Application M/56/15/HH: 31 Sea Way, Middleton-On-Sea, West Sussex, PO22 7RZ

I wish to enter my objection to the above proposed development on the following grounds:

ROOF PLAN
1.100

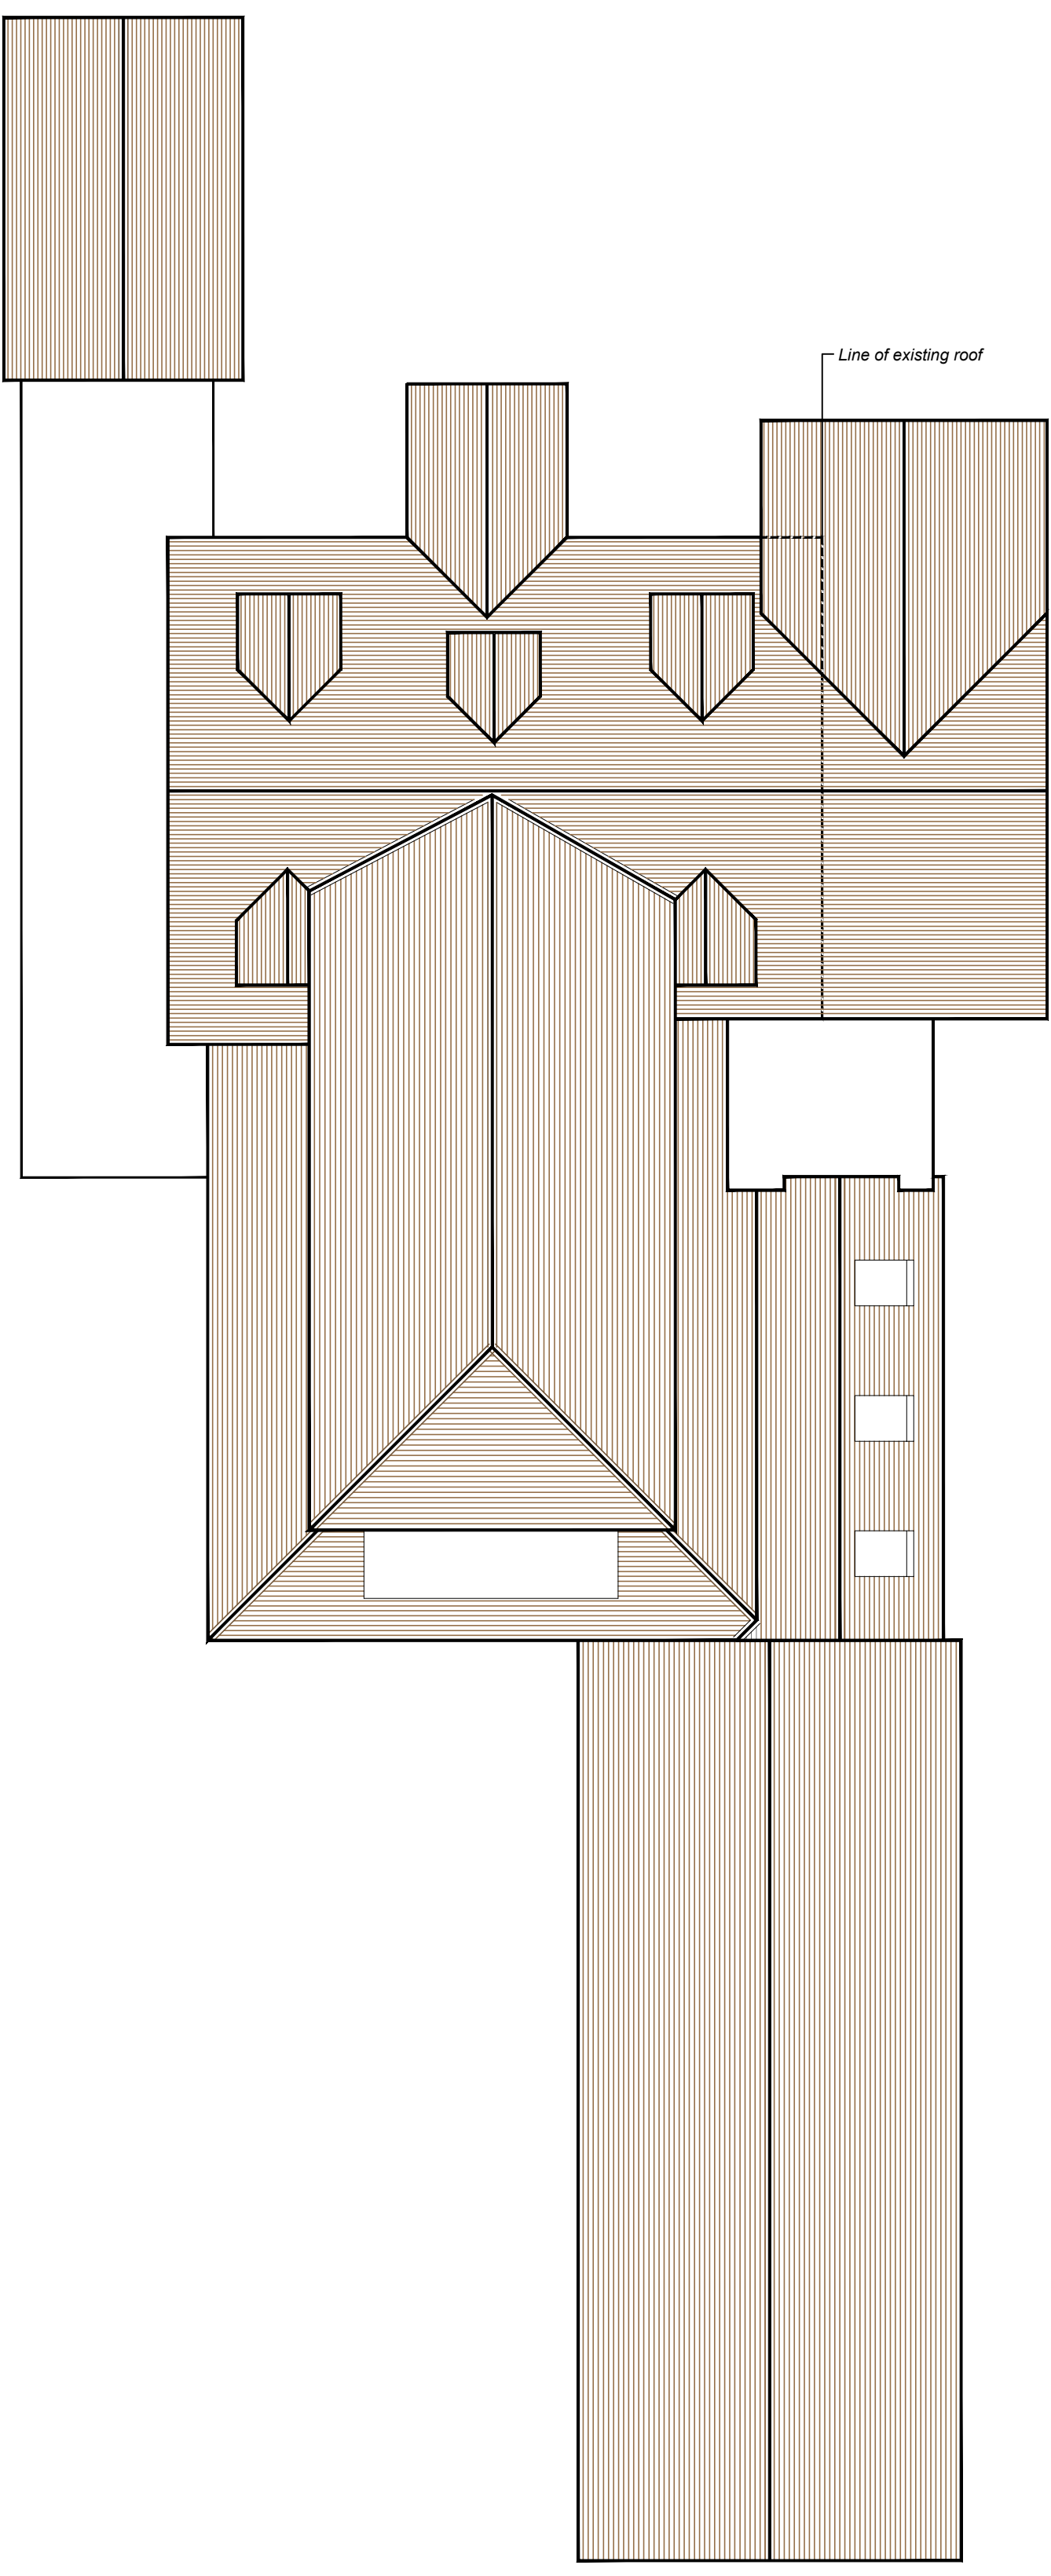
3. No part of the increased development takes into account this area of special character and the open space enjoyed by each property, I therefore concerned at the impingement of loss of light and amenity to the neighbouring property of No 29 again as a precedent for future applications and the likely changes to both the view from the seafront and road.

4. The bulk of the 'blind' wall and high pitched roof of the proposed garage building so close to the boundary line at both the east and north. The long bulk of the building will seem quite dominating – even if the current hedging or new planting or indeed a wall were in place. Again the precedent of building so close to the boundary of a property close fronting

6. The possible damage to the recently re-instated and costly land drain that runs across Sea Way Road and takes a route (rain water that drains down from West Close/East Close) directly through 'The Little House' property to egress under The Greensward and shingle and out to sea. I appreciate that this may not be seen as a planning matter but I would want to have this item noted for further consideration and a specific note attached with regard to any future planning as the weight or disturbance of the proposed building work – in particular in this case the load bearing weight of the proposed garage and high pitched roof in the front of the property as well as the support structure for the proposed pool enclosure could materially affect the ability of the drain to work effectively.
